**Our Ref: AB/121/11/
Your Ref:**

Please ask for:
Mrs S Honney-Bayes
01903 737500 Ext 37445
29th November 2011

**New dwelling in garden & partial demolition of a single storey building. Amendment to previous approval AB/27/09/
55-57 High Street Arundel**

Proposed South East Elevation

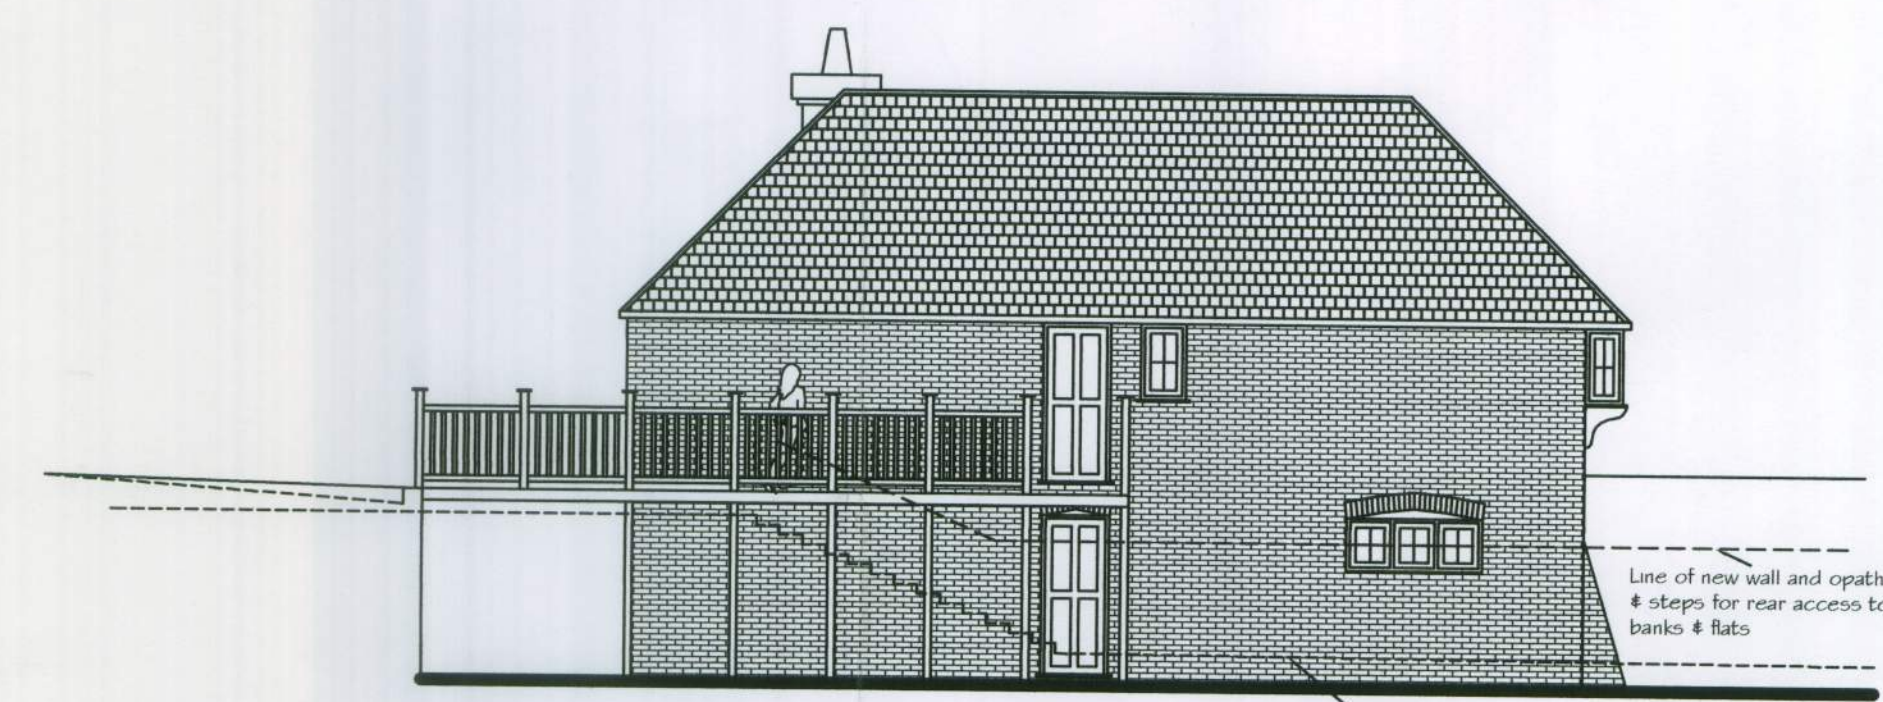
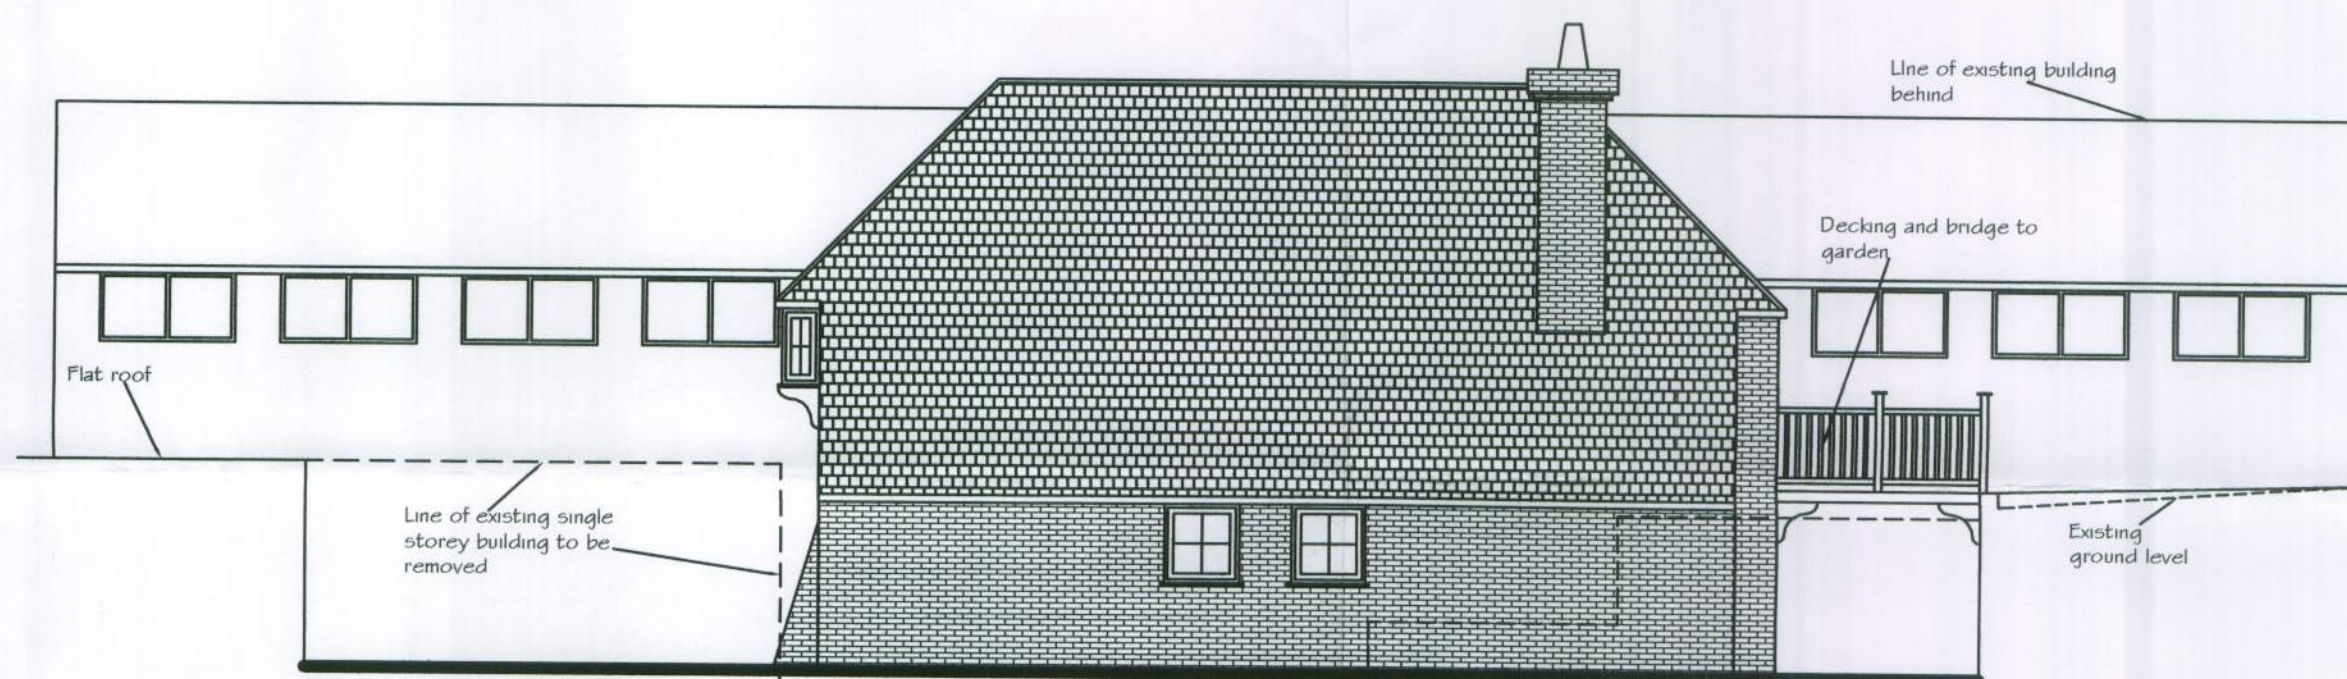
Please provide 1 electronic or 3 paper copies of a revised proposed first floor plan. The window (bedroom 1) does not accord with the elevations. It is shown on the north west and south east elevations, but this is not reflected on the floor plan. Please amend.
